Ribble Valley Borough Council
Development Control
Council Offices Church Walk
Clitheroe
Lancashire
BB7 2RA

Our ref: NO/2017/109902/01-L01
Your ref: 3/2017/0439
Date: 26 June 2017

DEMOLITION OF EXISTING DETACHED GARAGE. ERECTION OF SINGLE STOREY EXTENSION TO SIDE, WITH USEABLE ROOF SPACE FOR GUEST ACCOMMODATION. NEW SEPTIC TANK AND SOAKAWAY. NEW BURIED LPG TANK. ASSOCIATED EXTERNAL ALTERATIONS AND LANDSCAPING WORKS. SAGAR WOOD BIRDY BROW CHAIGLEY BB7 3LR

Drawing title:
Site Location Plan

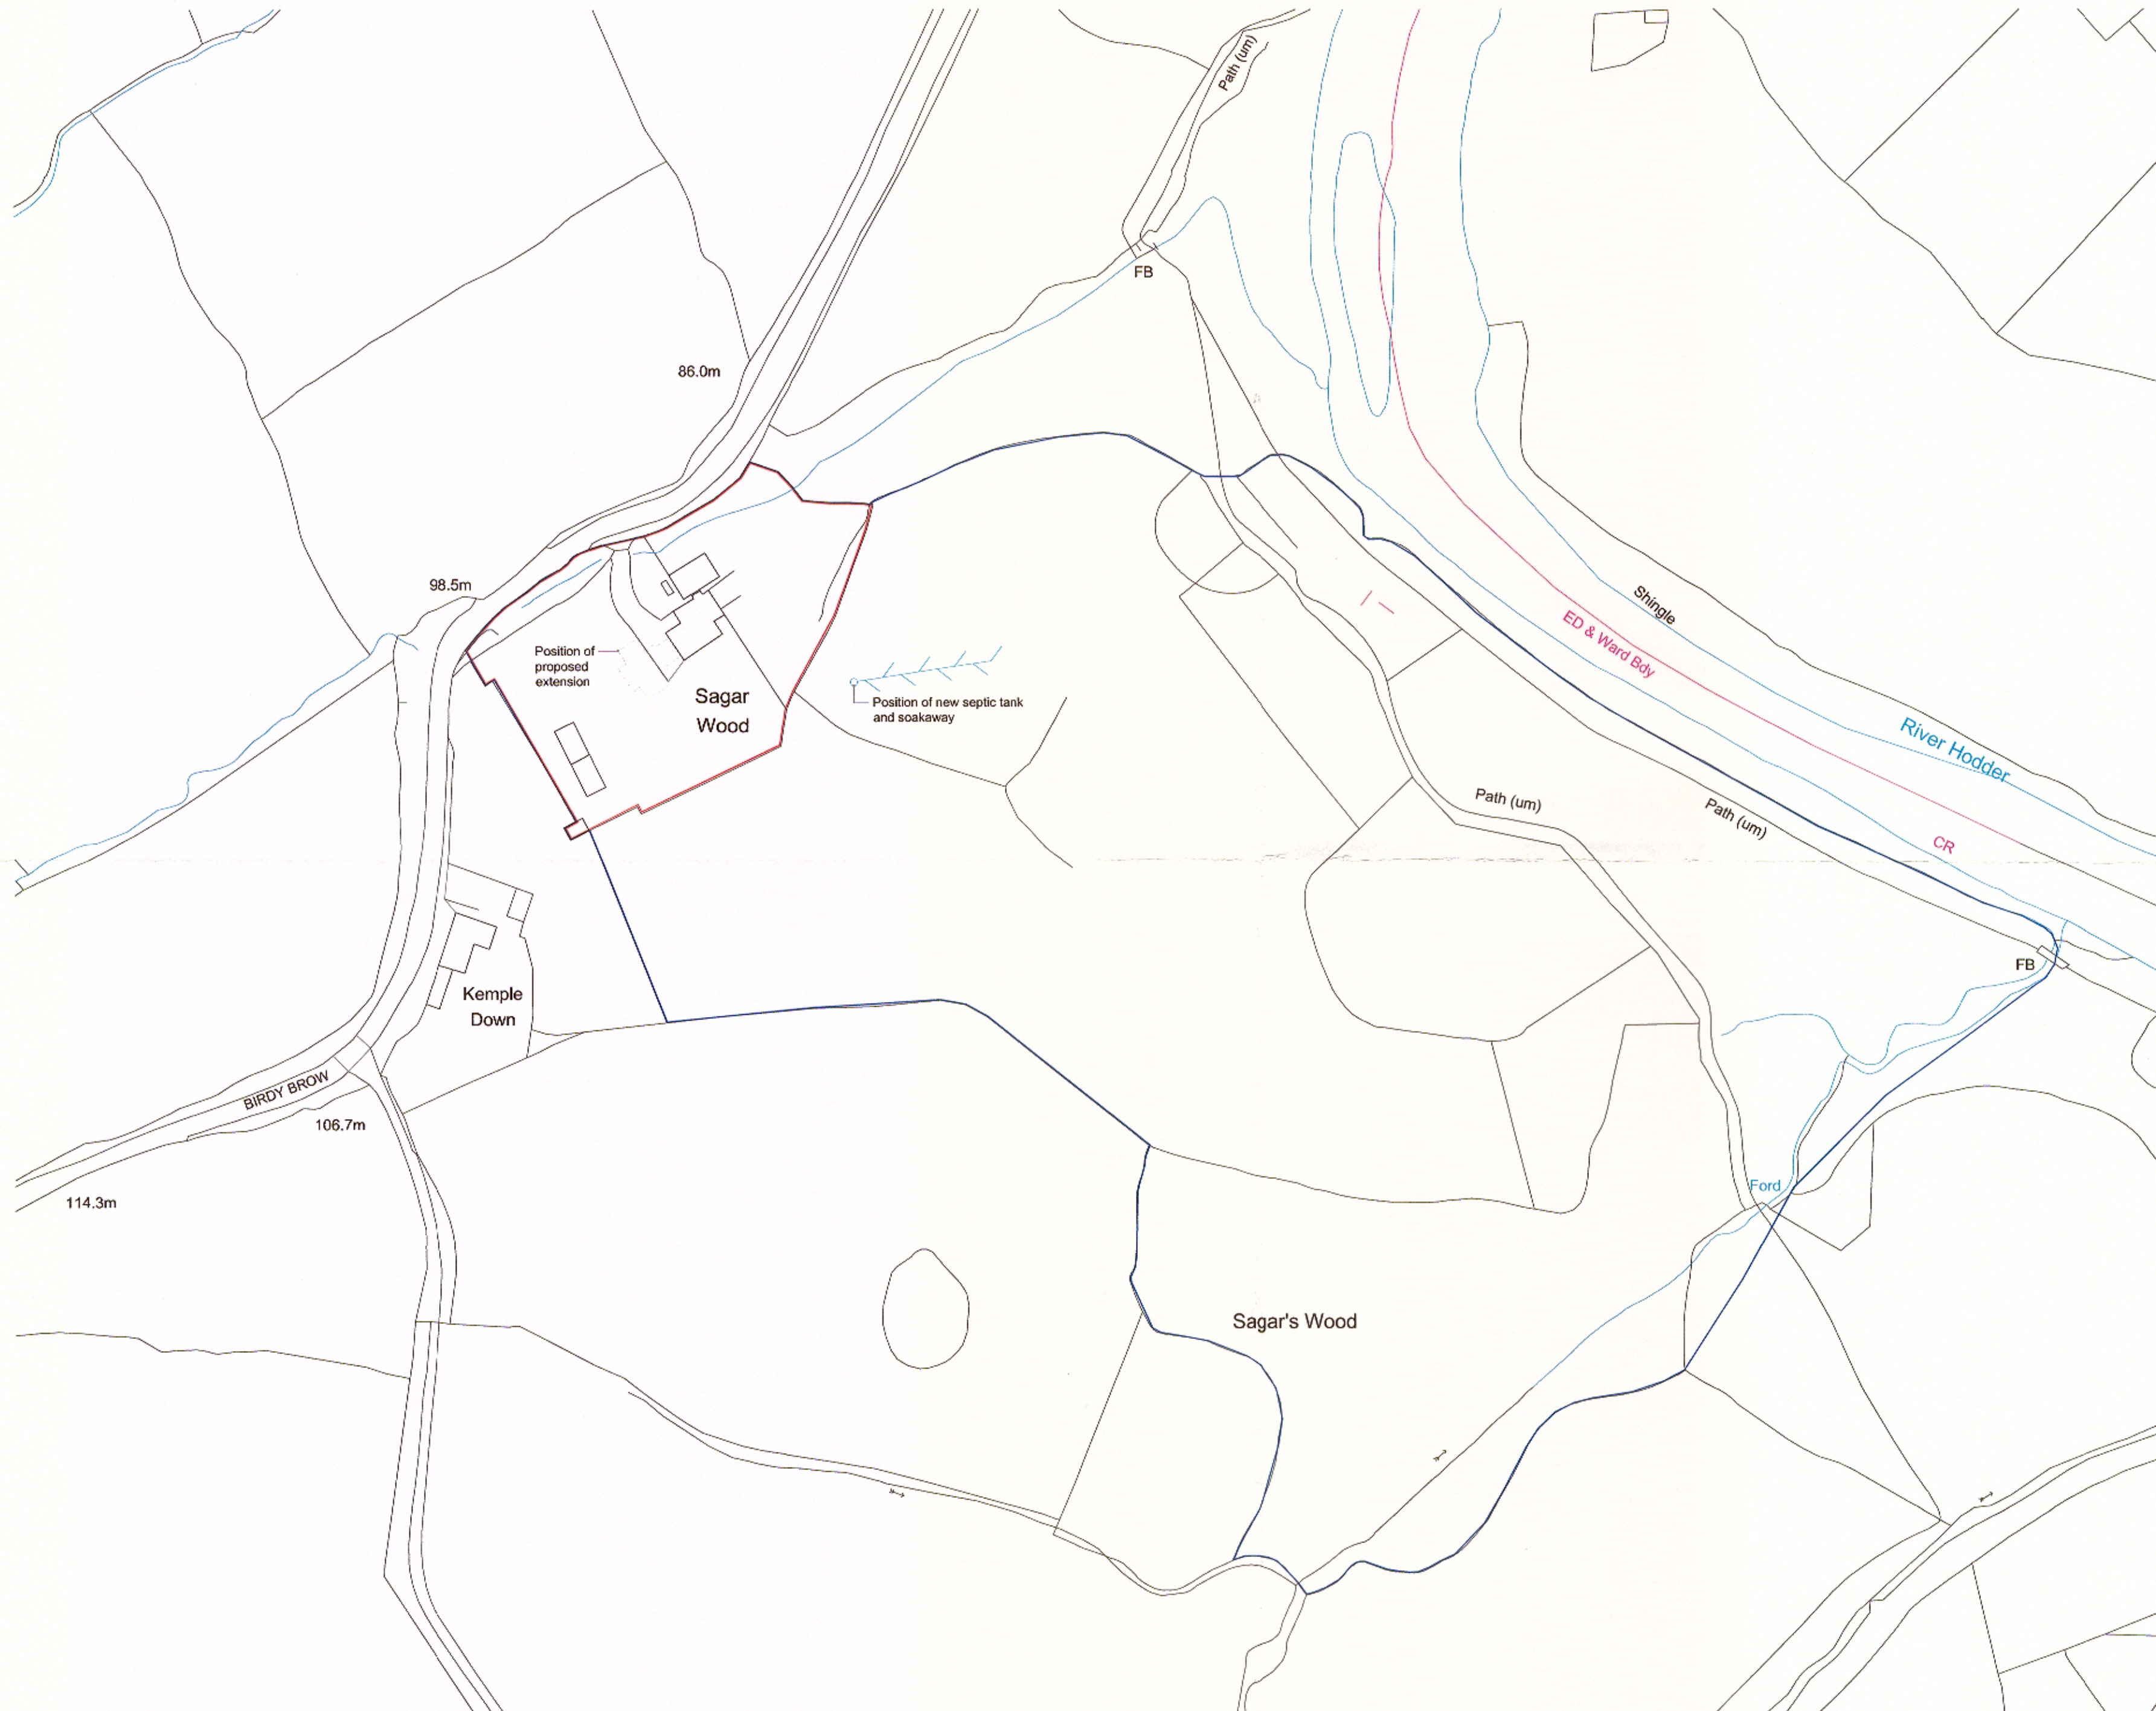
Government guidance contained within the national Planning Practice Guidance (Water supply, wastewater and water quality – considerations for planning applications, paragraph 020) sets out a hierarchy of drainage options that must be considered and discounted in the following order:

1. Connection to the public sewer
2. Package sewage treatment plant (adopted in due course by the sewerage company or owned and operated under a new appointment or variation)
3. Septic Tank

A soakaway used to serve a non-mains drainage system must be sited no less than 10 metres from the nearest watercourse, not less than 10 metres from any other foul soakaway and not less than 50 metres from the nearest potable water supply.
